From: Kathryn Welch
Sent: 19 December 2025 14:56
To: Planning Scanning
Subject: FW: LU/173/25/PL

CARAVAN & MOTORHOME SITE PLAN

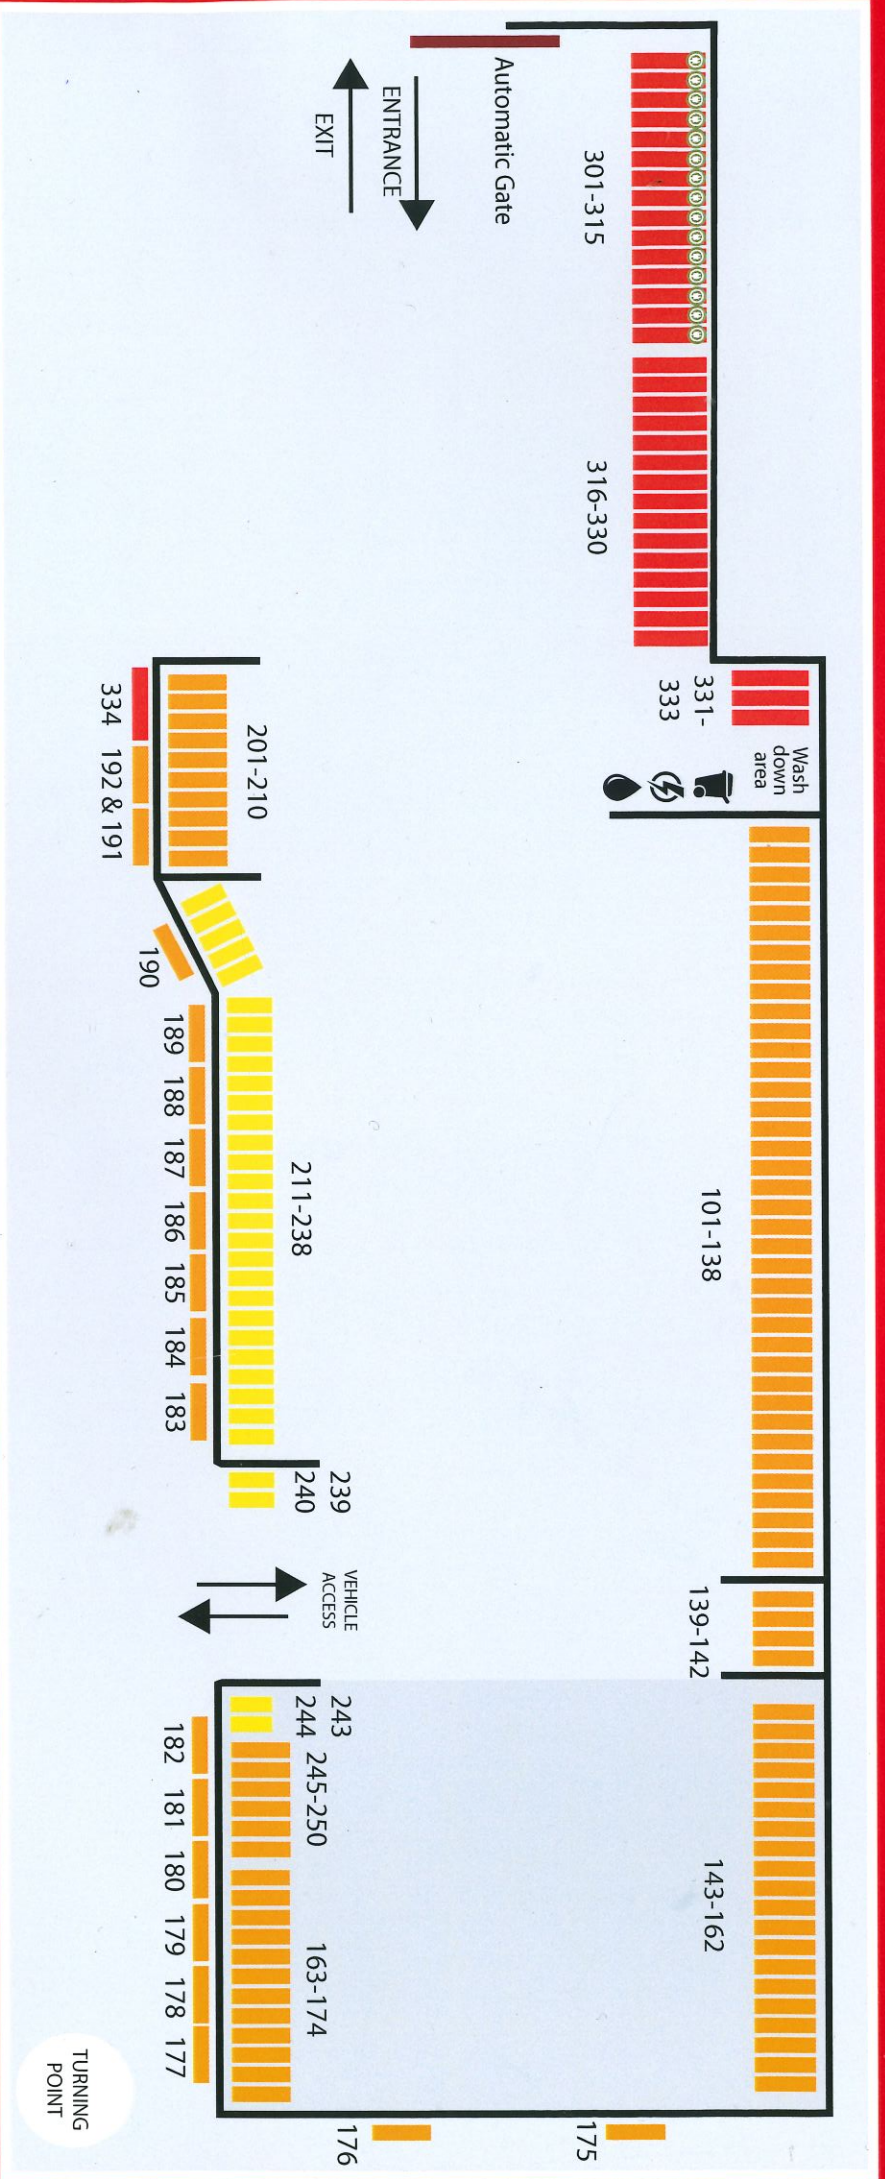
I can see that the proposed parking plan indicates that 36 HGV spaces are proposed; this differs slightly from your email of the 7 October which stated 42. Could you confirm that it is now 36 spaces proposed?

A parking plan showing the proposed parking arrangements would be helpful. I understand we have some of this information in a recent explanatory email, but a plan detailing this can form part of the approved documents condition.

The client has confirmed it will now be 36.

I attach a revised plan of the vehicle storage to include for the HGV use of the western part of the site.
